Response to Submissions - State Significant Development Application and Variation of the Sydney Cove Redevelopment Scheme for the “*Remediation, Renewal and Adaptive Re-Use of Campbell's Stores*”, The Rocks (SSD 7056)

SAKE Development with GMU Urban Design & Architecture; and Clive Lucas, Stapleton & Partners Heritage Consultants have reviewed the applicant's Response to Submissions (RtS) report, architectural drawings and associated documentation on behalf of the owners and residents at 8 Hickson Road The Rocks. On review of this documentation, we continue to strongly object to the proposed new four storey glass addition to the north of the Campbell's Stores (the Stores) and any variation to the Sydney Cove Redevelopment Authority Scheme to support this development. Our original submission and objections therefore stand.

03 NORTH ELEVATION  
SCALE 1:200

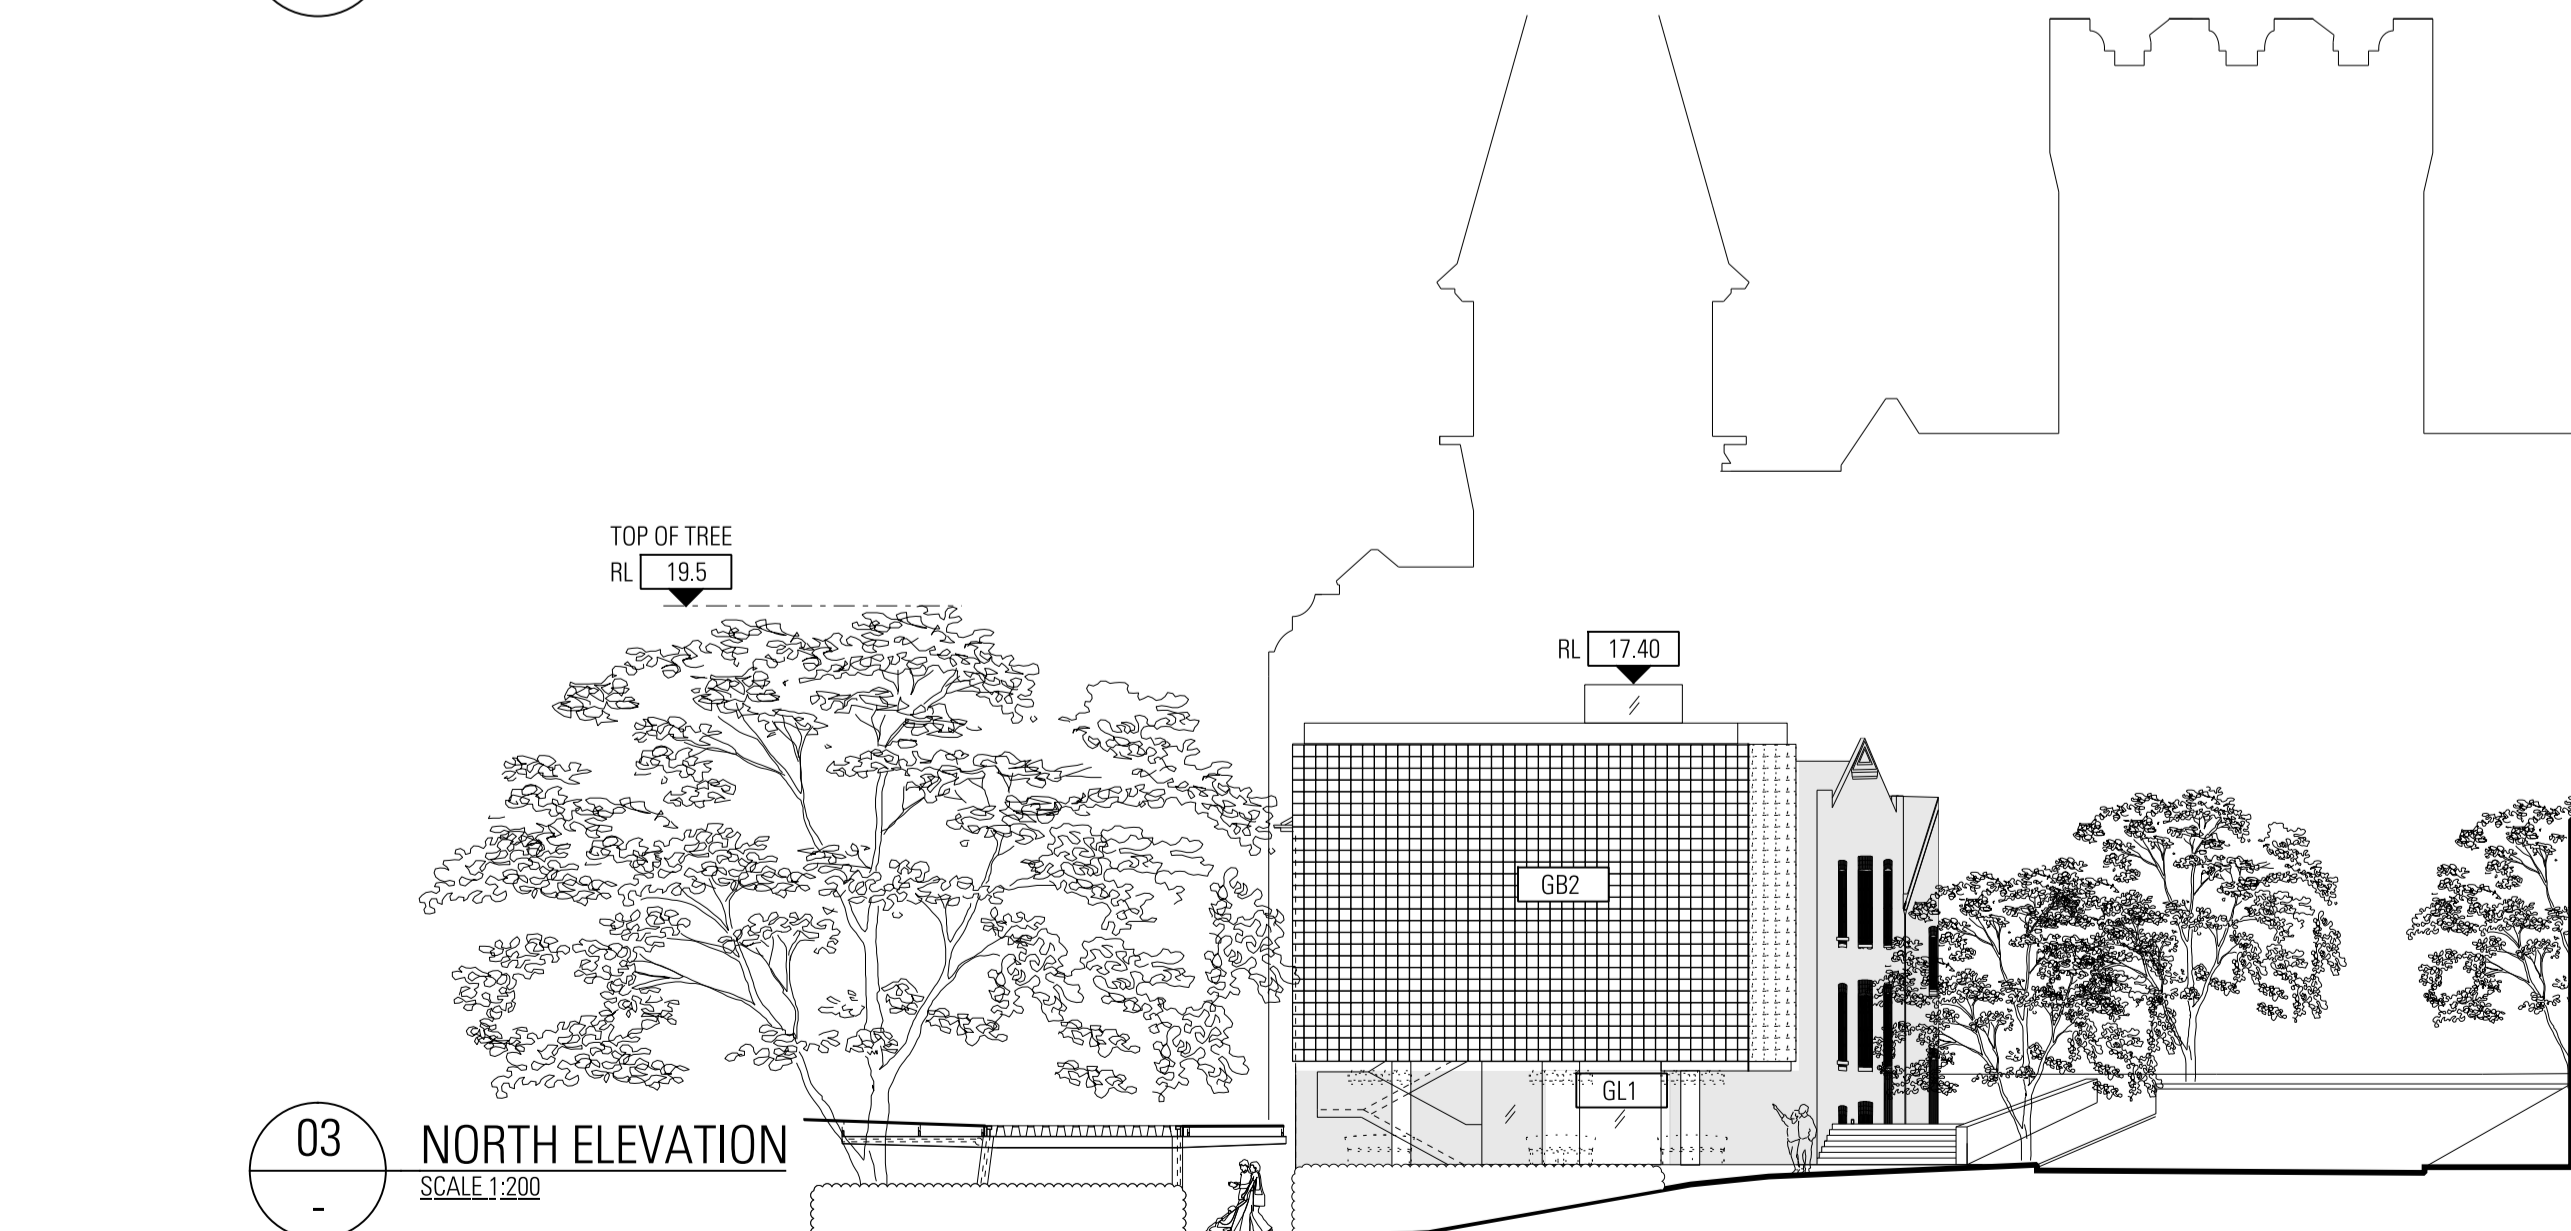
- The modest changes to the new four storey glass addition are token at best and fail to address our real concerns about this new building, which we still consider is an intrusive and ill-conceived structure that will have negative visual impact.

- The proposed modifications do not significantly change the overall massing and essence of the design which will significantly depart from the historic urban fabric. The proposed 'glass box' lifted on stilts with no fenestrations and vertical architectural elements introduces a new fabric and architectural expression into this heritage area.

- The proposed building's alignment with the highest point of Bay 11 and its 11 metre width are inconsistent with the form of the other bays. The height of any future building in the Bay 12 area should therefore be reduced to comply with the current building envelope control in the SCRAS scheme, being RL7.50m.

- The proposed new glass building still does not comply with the building envelope control as shown on the axonometric drawing provided on the SCRA Scheme. The current control would only allow a single storey building.

- The proposal exceeds the height restriction on the foreshore frontage by some 14m, and on the Hickson Road elevation by some 10m. Along the foreshore, the applicant is seeking to increase the height from RL3.5 to RL17.4, almost 5 times the current permissible height limit.

- As such, the height of any building in this location should be reduced to comply with the current building envelope control (between RL 3.50m to RL7.50m) and there should **be no variation of the SCRAS.**

HICKSON ROAD ELEVATION (NTS)

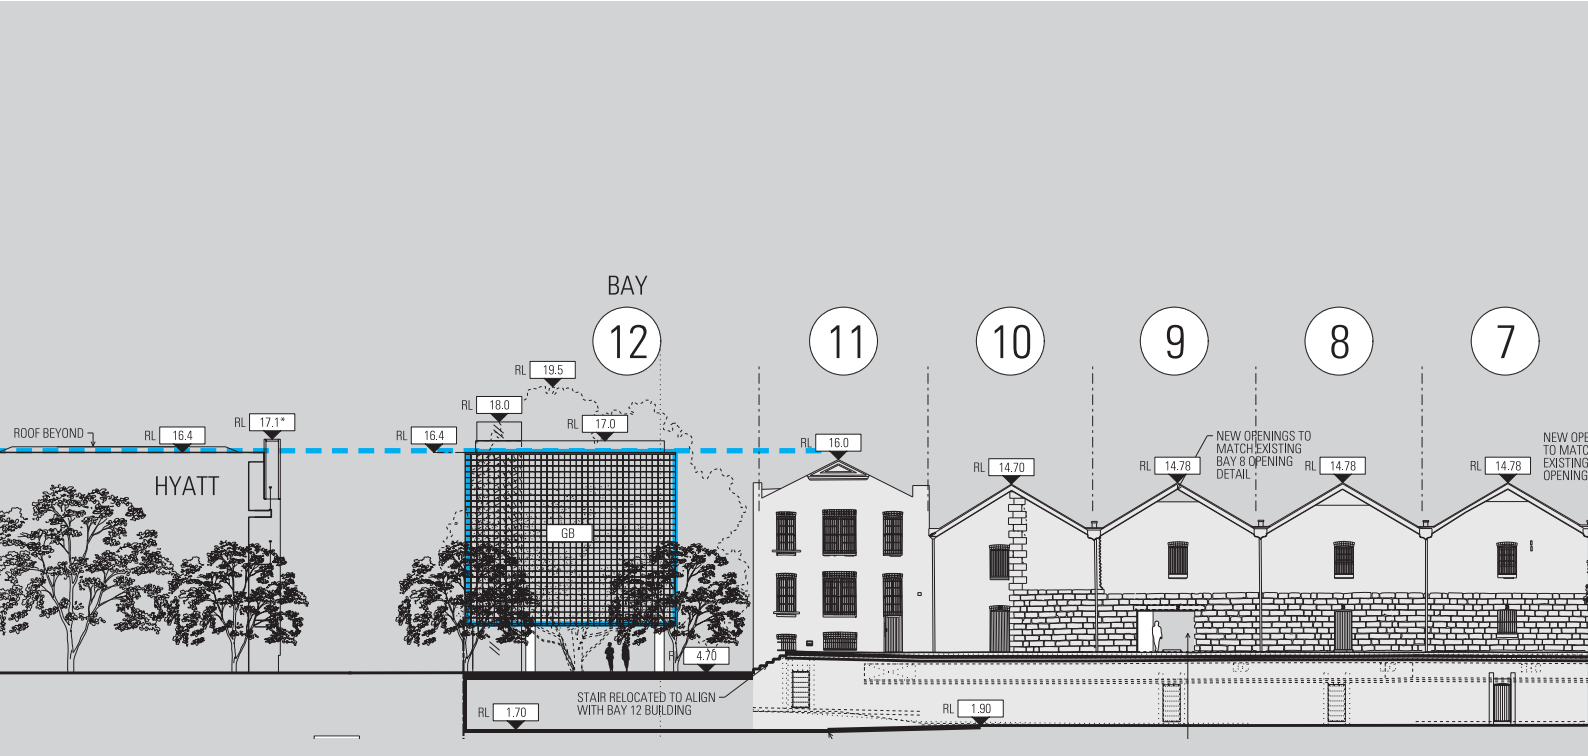
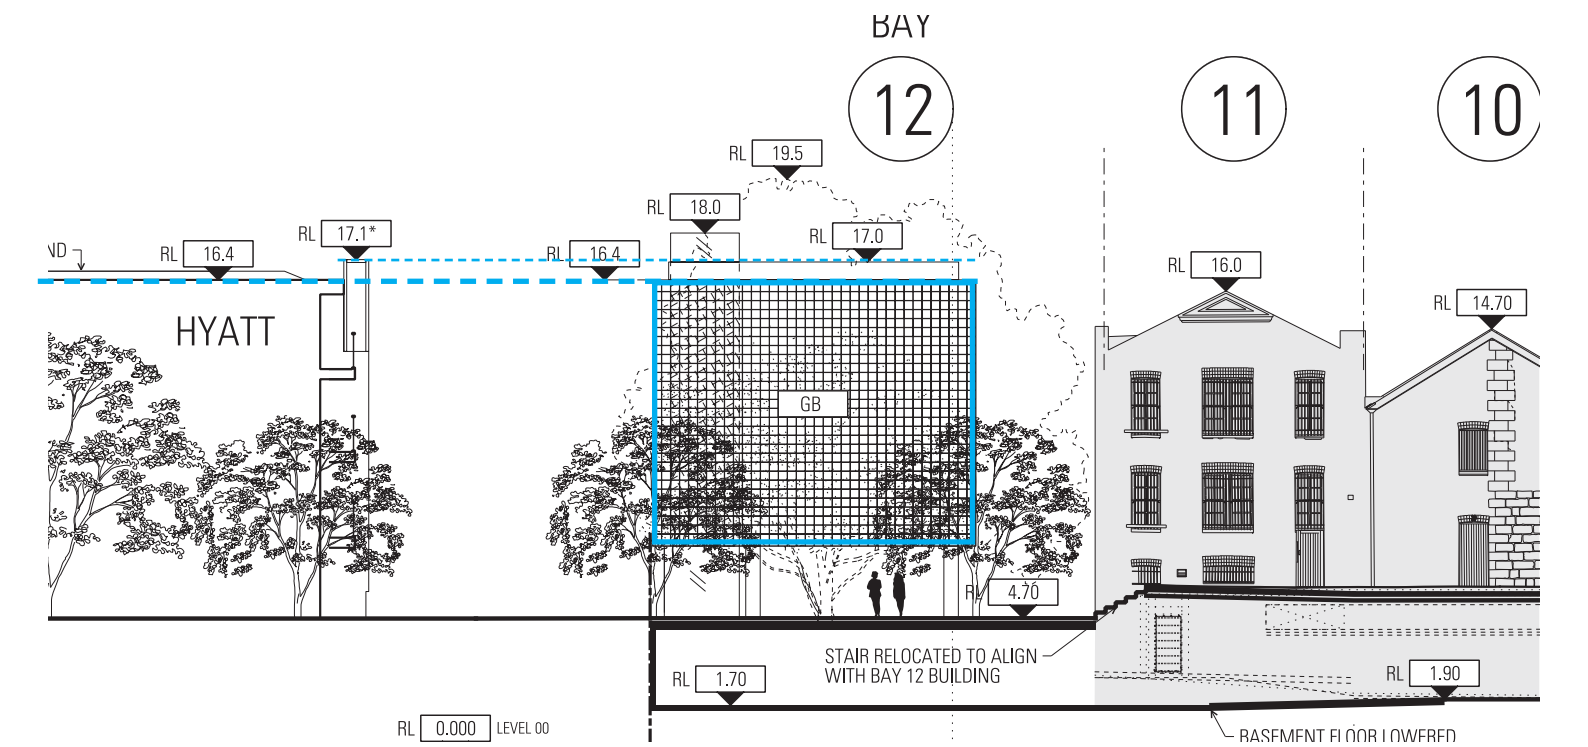
- The SCRAS' height restrictions were established to create a visual separation between Campbell's Stores and the Park Hyatt and to create an open space and visual connection in this location. This will be destroyed if the non-compliance is approved.
